PLANNING CONSULTATION REPLY

APPLICATION: 35 Wood Walk, Wombwell, Barnsley, S73 0LZ.

2 0 2 2 0 6 7 9

Undertake pruning works as detailed in the tree report to trees protected by TPO 18/1975 at 35 Wood Walk, Wombwell.

Figure 1. Damaged stem at the crown of T1.

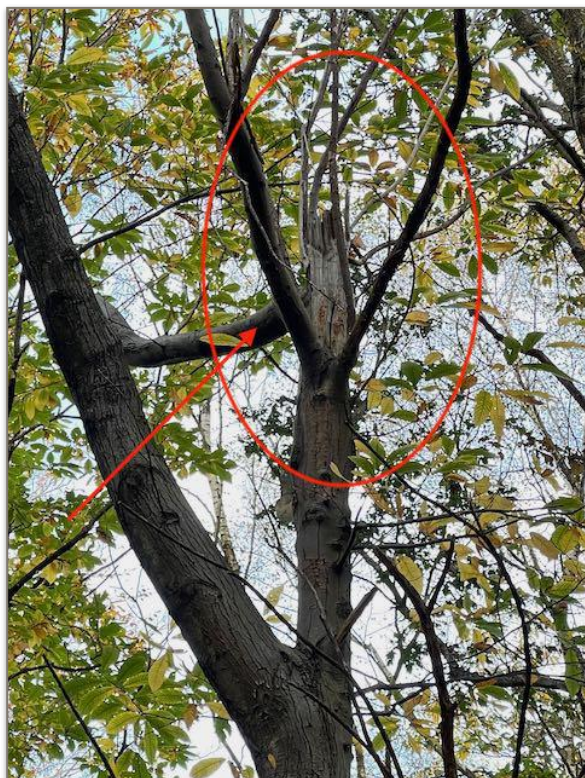
The works proposed in the main are for the removal of deadwood which is exempt from needing permission, however works beyond this are proposed for Sweet Chestnuts T1 and T5. It is proposed to remove the poorly attached limb located just above a cavity at 9m from T1 and clean up the damaged and torn branches from T5.

The works as described are all sensible and proportionate and as such there is no objection to them being undertaken as described in the tree report from an arboricultural perspective.
